**From:** Contact Centre (CRM) <contact@ribblevalley.gov.uk>  
**Sent:** 04 February 2025 13:31  
**To:** Planning  
**Subject:** Planning Application Comments - 3/2024/1016 FS-Case-684623990

**Planning Application Reference No.:** 3/2024/1016

**Address of Development:** 1 to 7 The Picture House George Street Whalley BB7 9TH

UPVC SURVEY OF WHALLEY CONSERVATION AREA AND PROPOSED EXTENSION TO ITS BOUNDARY

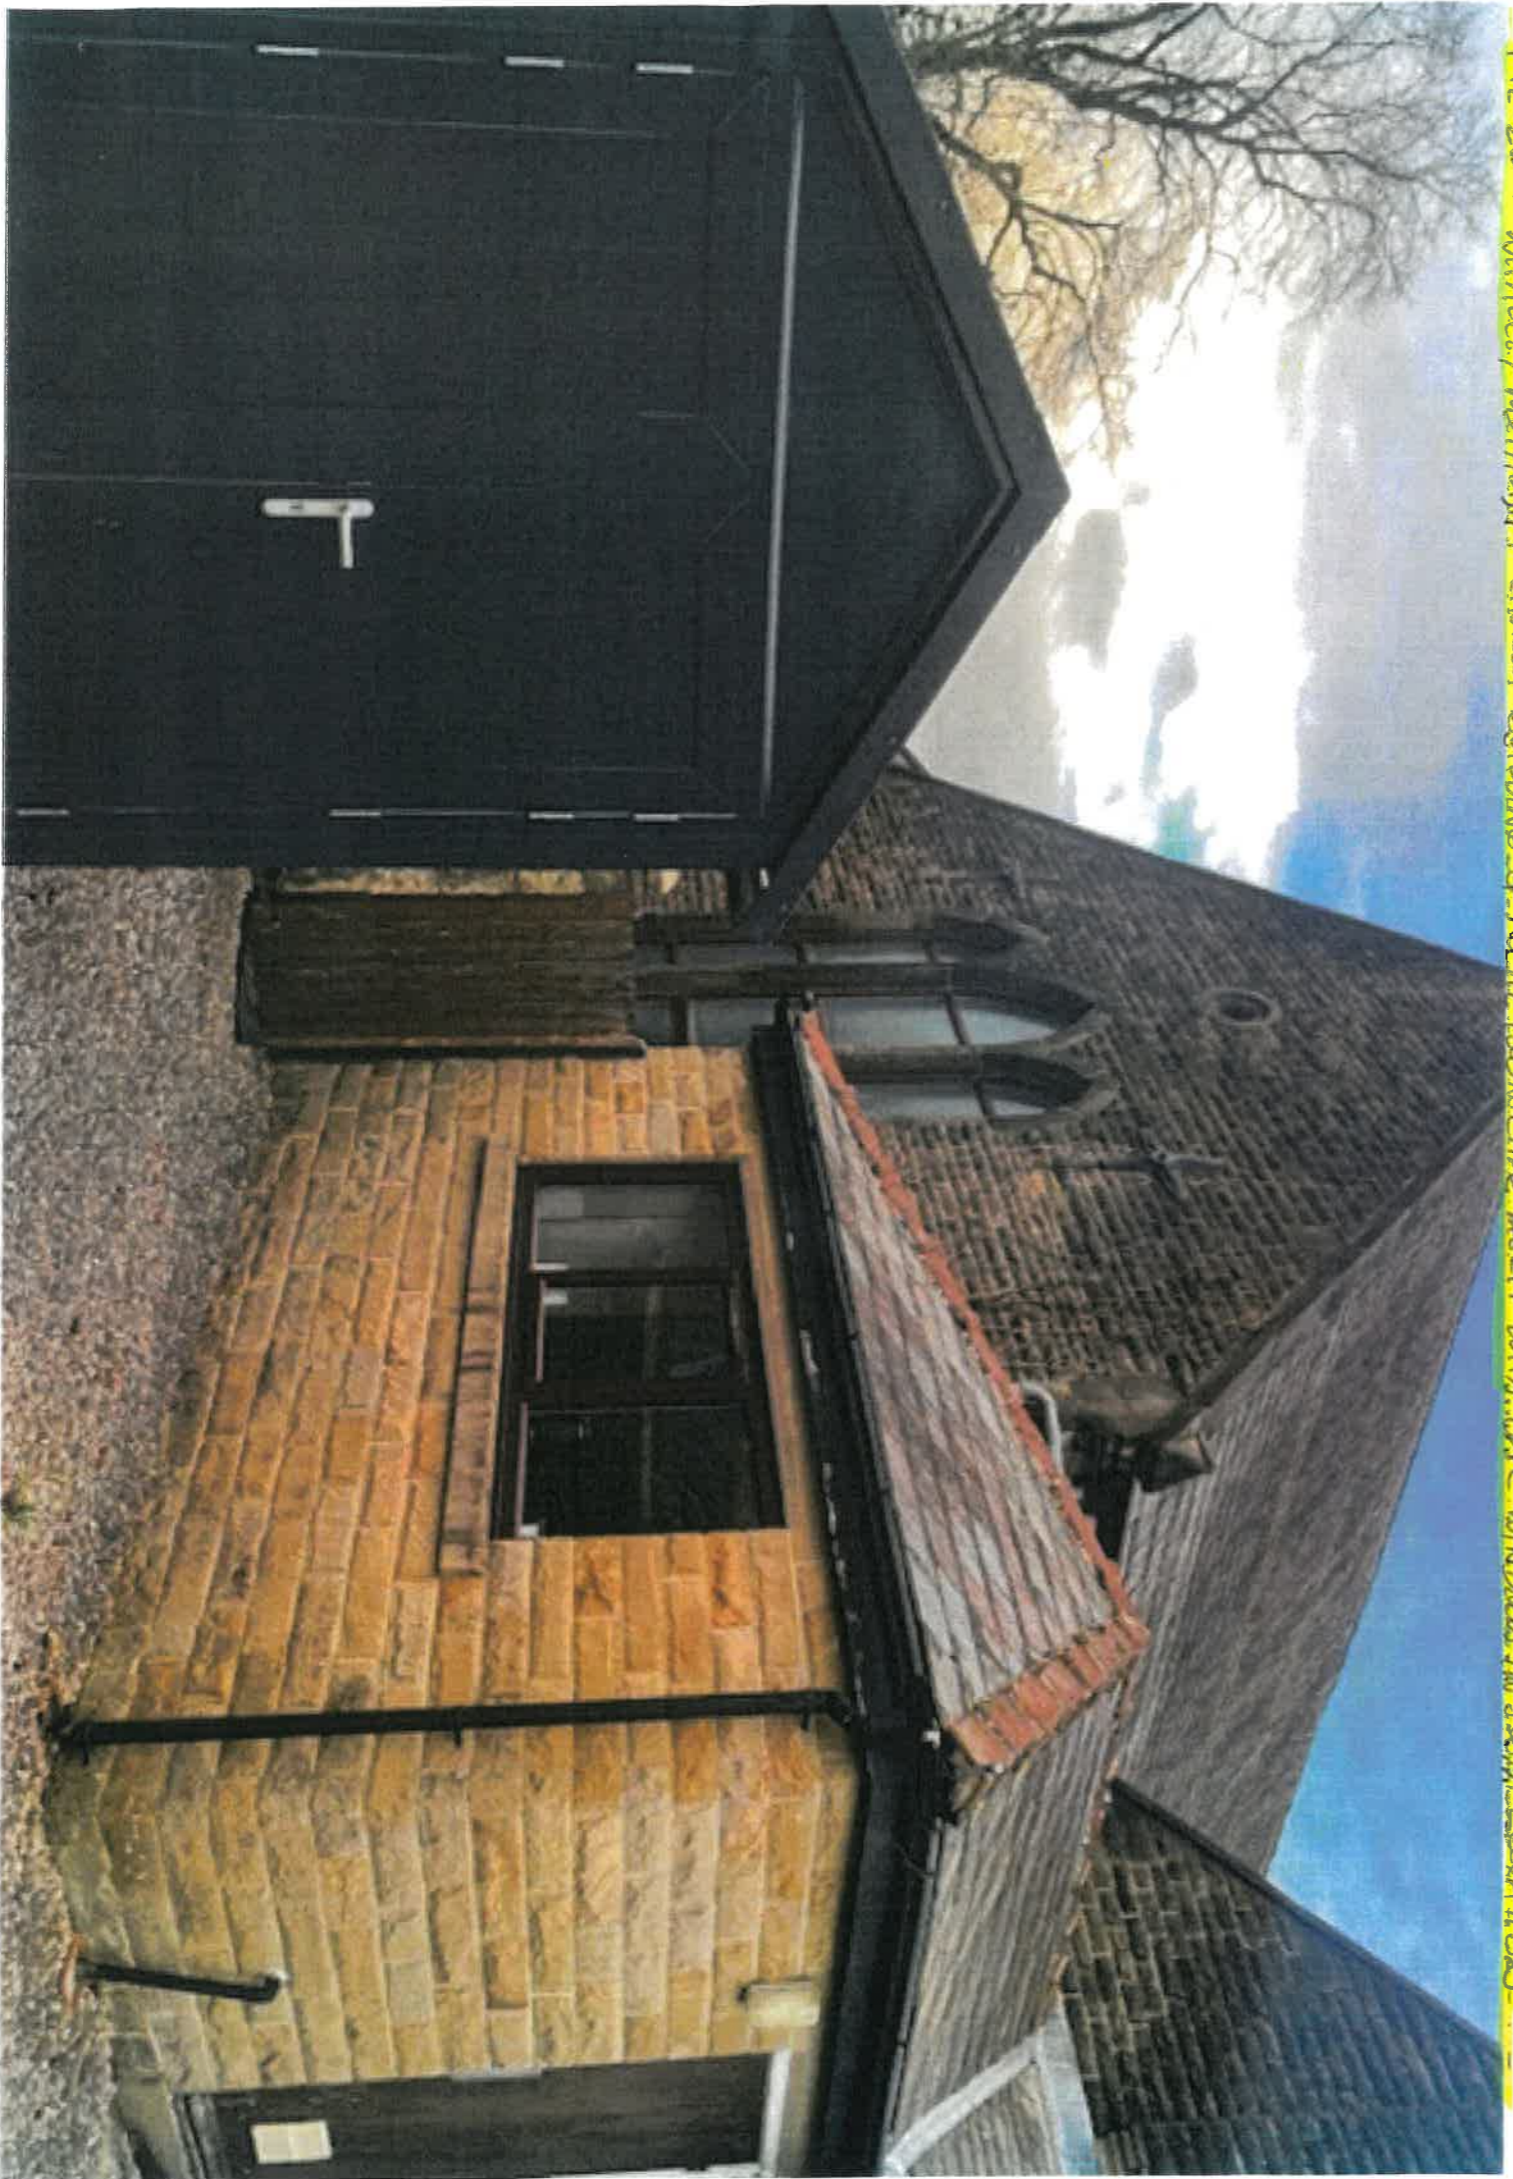
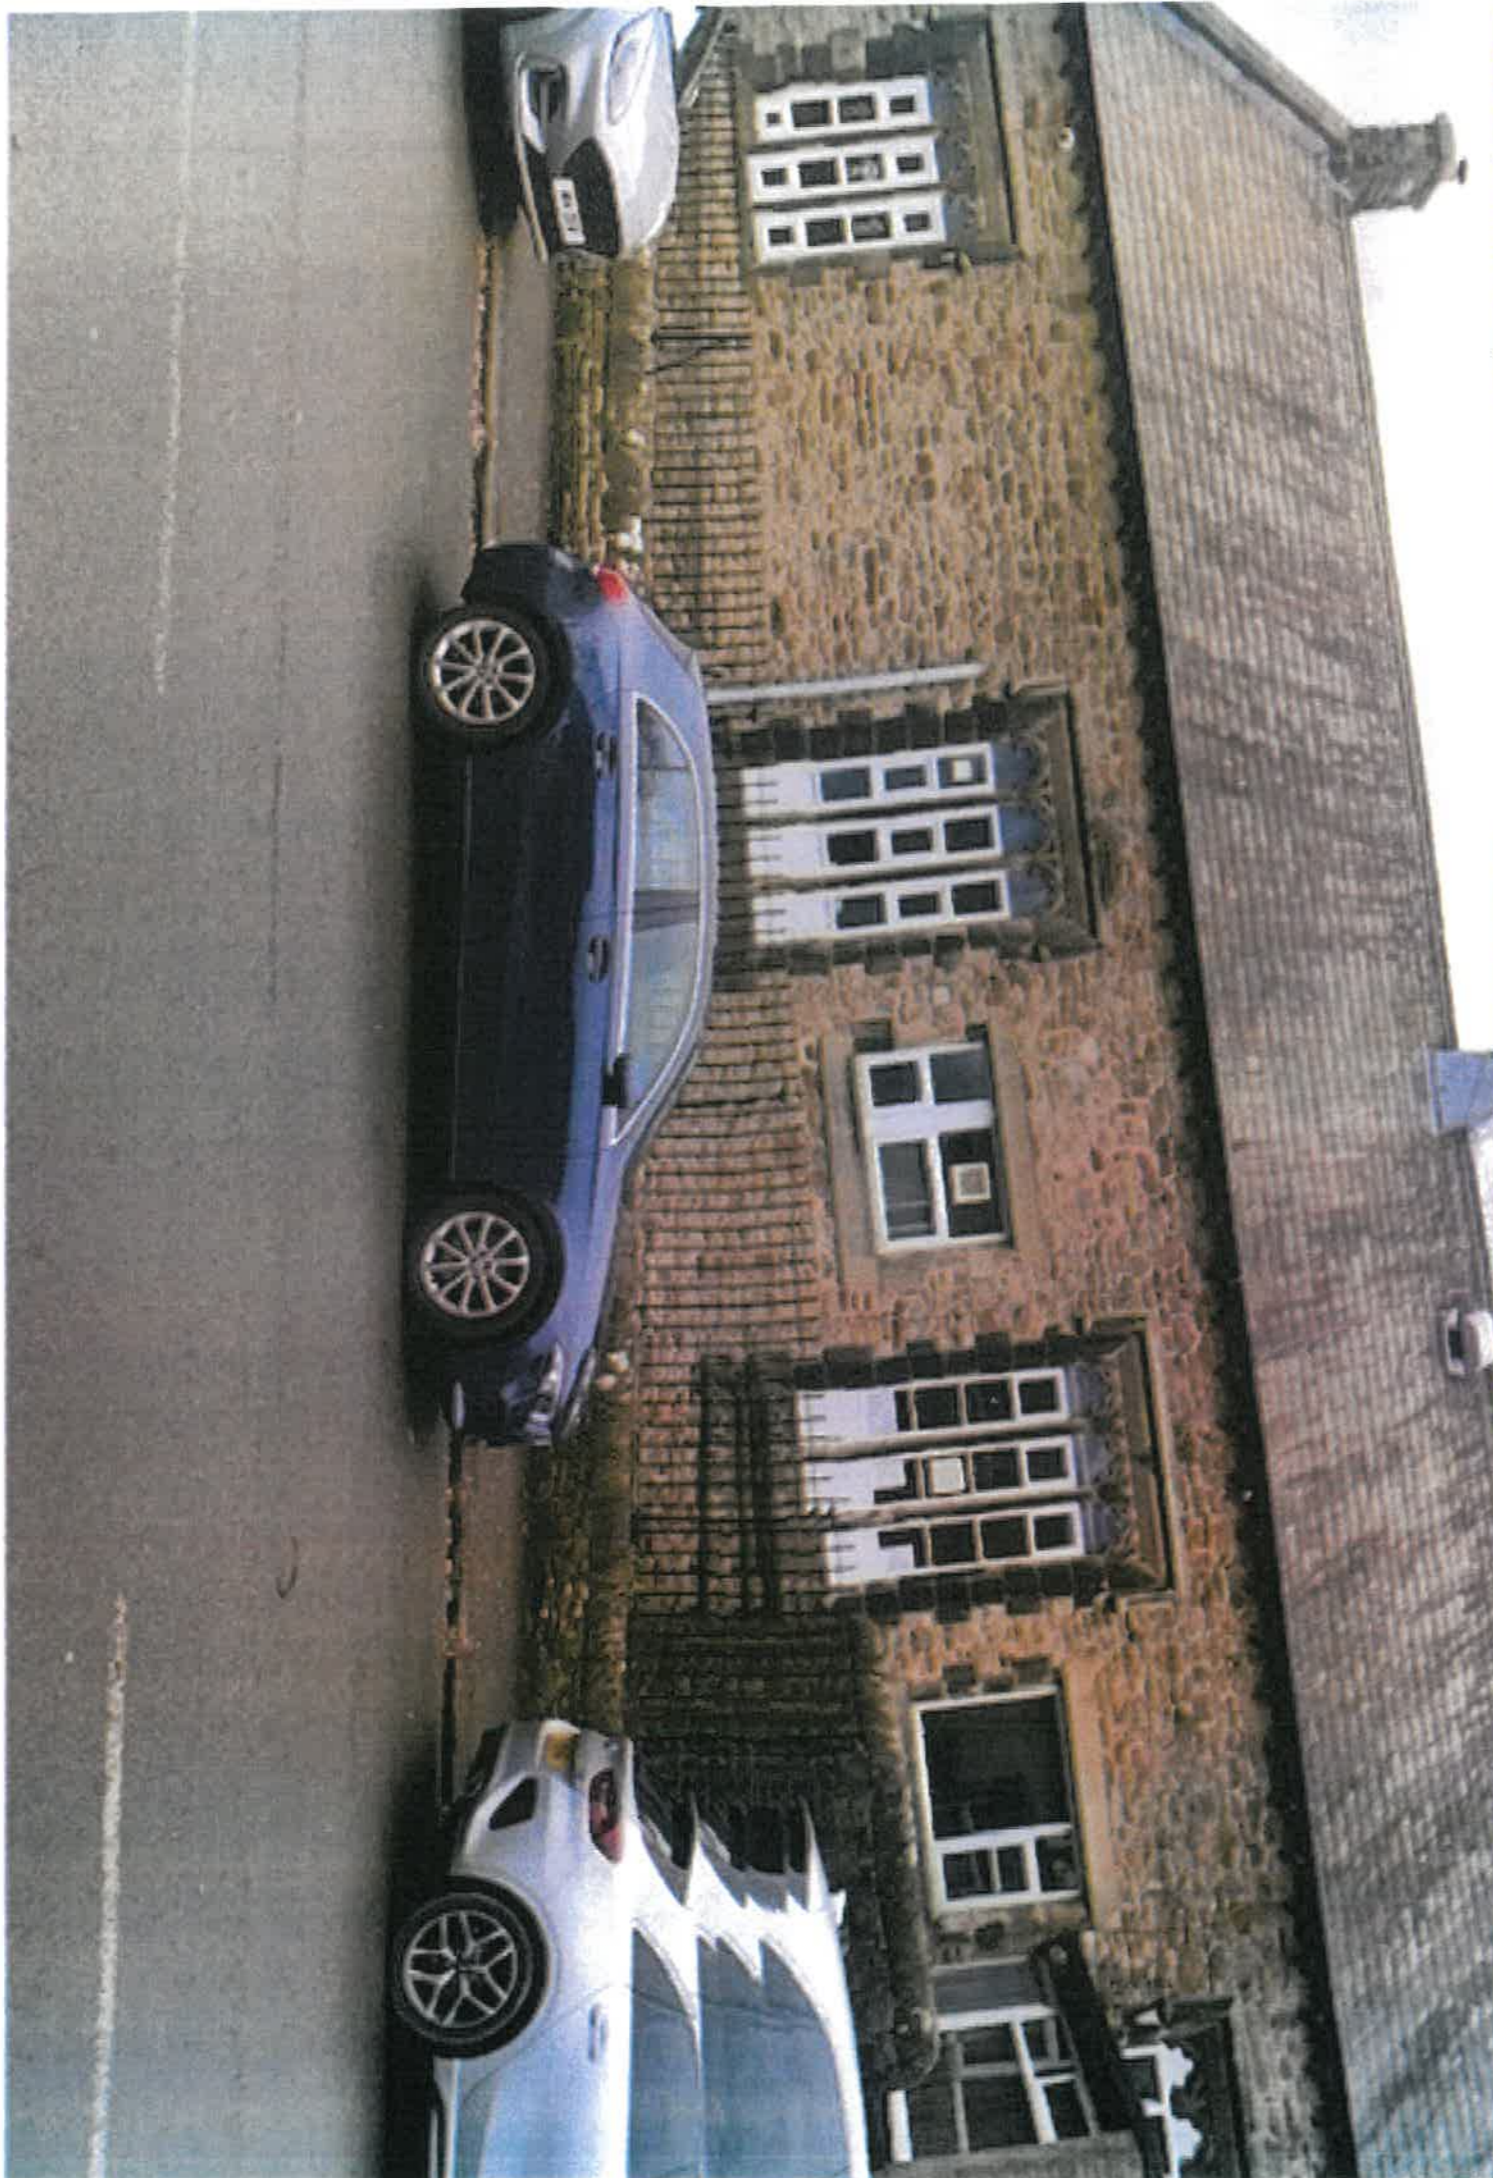
#### 5. Replacement of UPVC Windows

While the applicant states that the new UPVC windows represent an improvement over the existing windows, the use of such materials remains highly contentious in conservation areas. The new windows are not compatible with the historic character of the area and undermine the integrity of the original design. The applicants' reference to the use of UPVC in nearby properties does not justify this choice, as it represents a broader trend of erosion of the conservation area's character. The proposal should be revisited with alternatives that are more in keeping with the historical context and architectural style of the building and surrounding area.
